**Consultation Response from KC,  
Lead Local Flood Authority**

**2022/93766 Syngenta Ltd, Leeds Road, Huddersfield, HD2 1FF**

**Erection of three industrial sheds on existing industrial site**

**Date Responded: 18<sup>th</sup> November 2022**

Figure 4: Flood Map for Planning (Rivers and Sea)

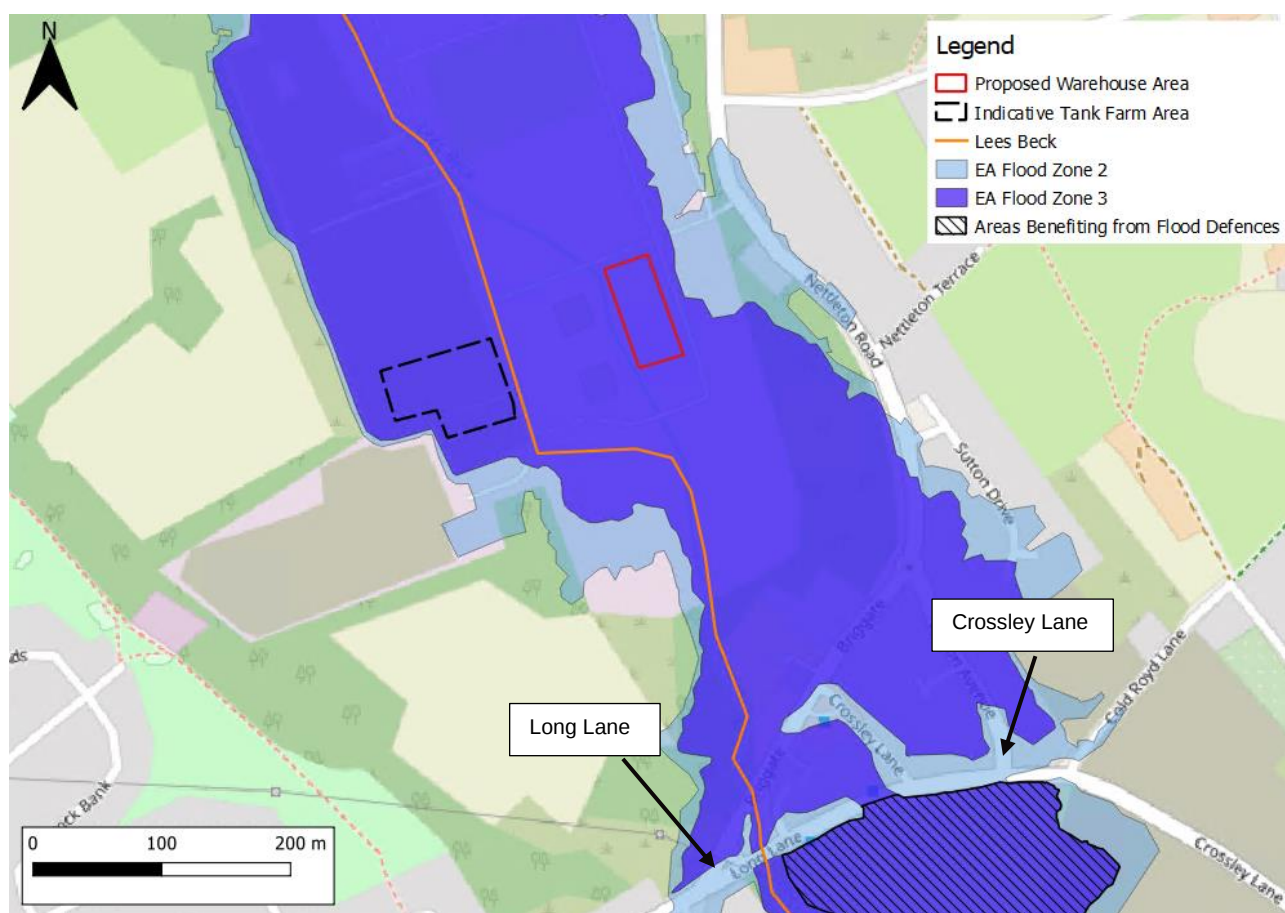
The site does require an official **SEQUENTIAL TEST**. However as being an extension of an existing business, the comparison area may be limited to the red line boundary which will produce a pass. The planning officer must confirm this. We do suggest that any new buildings are located within the areas of least risk within the site. This is known as a **SEQUENTIAL APPROACH**. The planning officer needs to advise whether this is reasonably practicable before we can move on to the submitted flood risk assessment. At the moment all new buildings are located in the zone of highest risk.

The FRA is deemed inadequate. First the EA must comment on main river flood risk in full including compensatory storage requirements and the setting of appropriate FFL's. It appears the developer is looking for levels below the usual standards due to the configuration of existing buildings.
